Your Ref 2023/92448

**Proposal: Outline application for erection of B8 industrial unit**

**Location: Former Cooper Bridge Water Treatment Works, Leeds Road, Huddersfield**

**Waterway: Calder & Hebble Navigation**

SITE PLAN

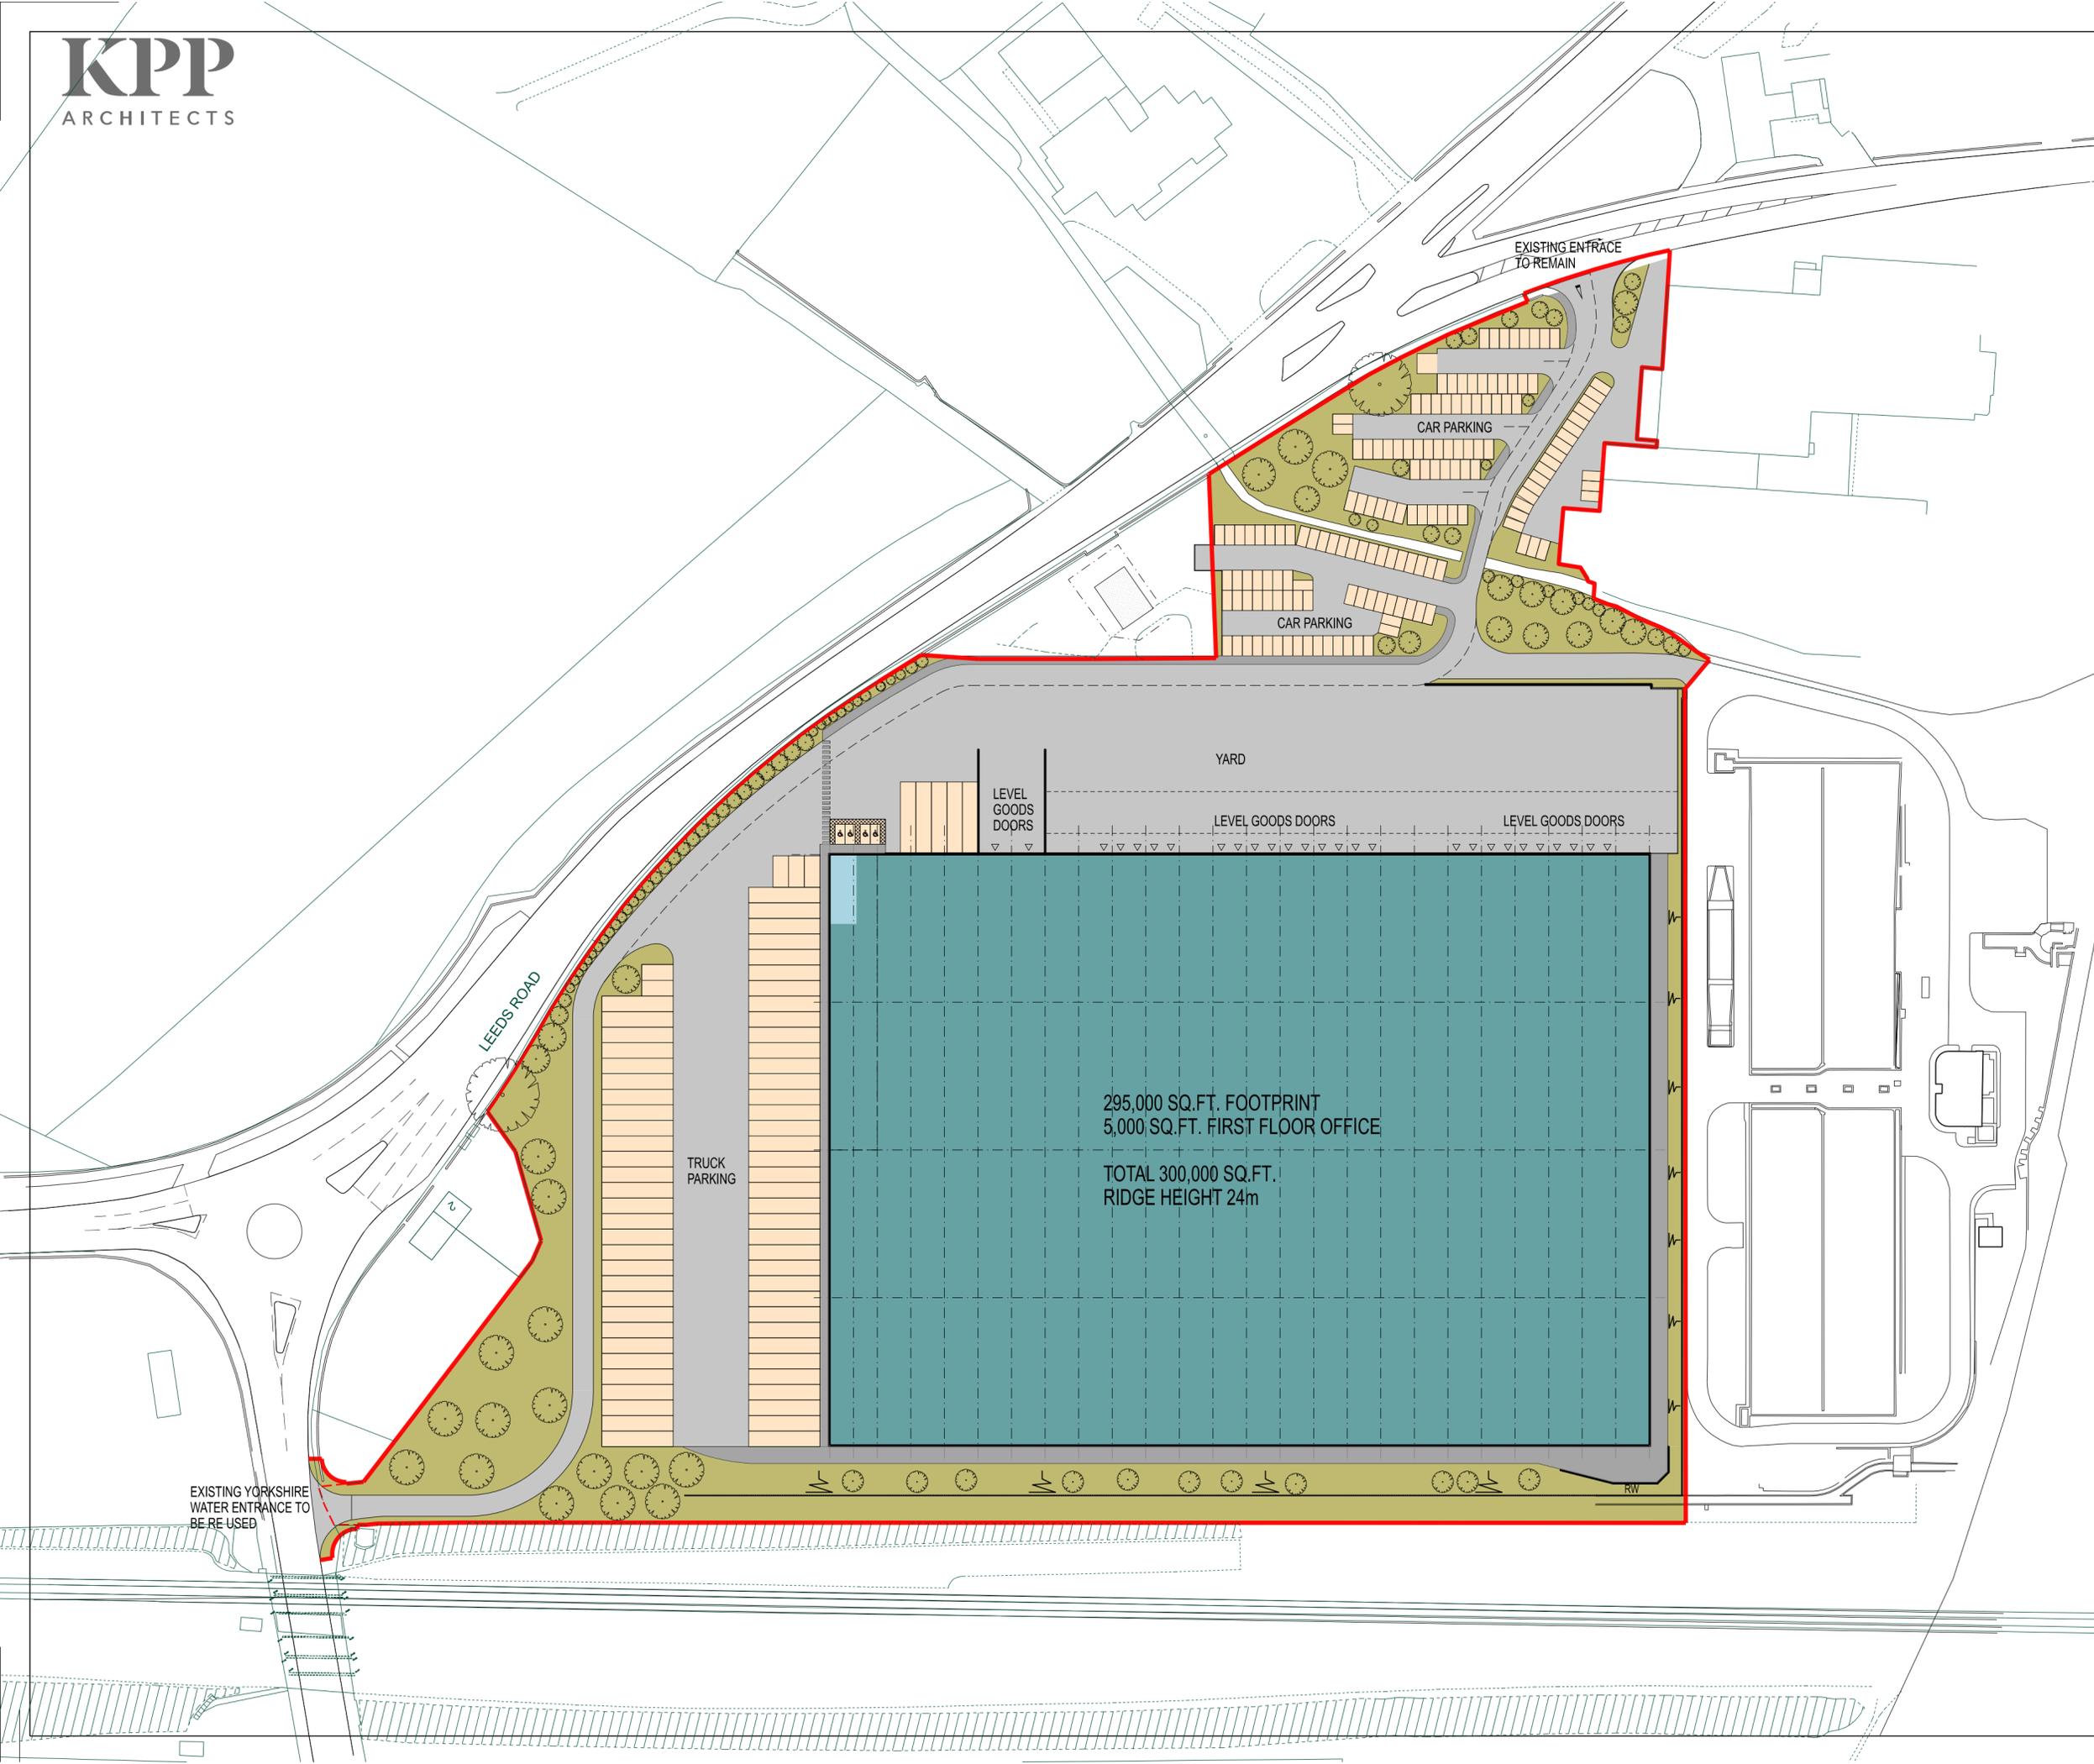
The parameters plan submitted with the application shows a landscaped area to the east of the new building, between the new build and retained filtration tanks. The parameters plan show that this would not extend to encompass the width of the whole building, stopping short of the North elevation. We request that, should the

scheme be developed further beyond outline stage, that the final design should seek to incorporate a landscape buffer that extends across the entire width of the building, which would help to reduce the prominence of the building from long distance views from the river, which could help retain the semi-natural character of the river corridor.
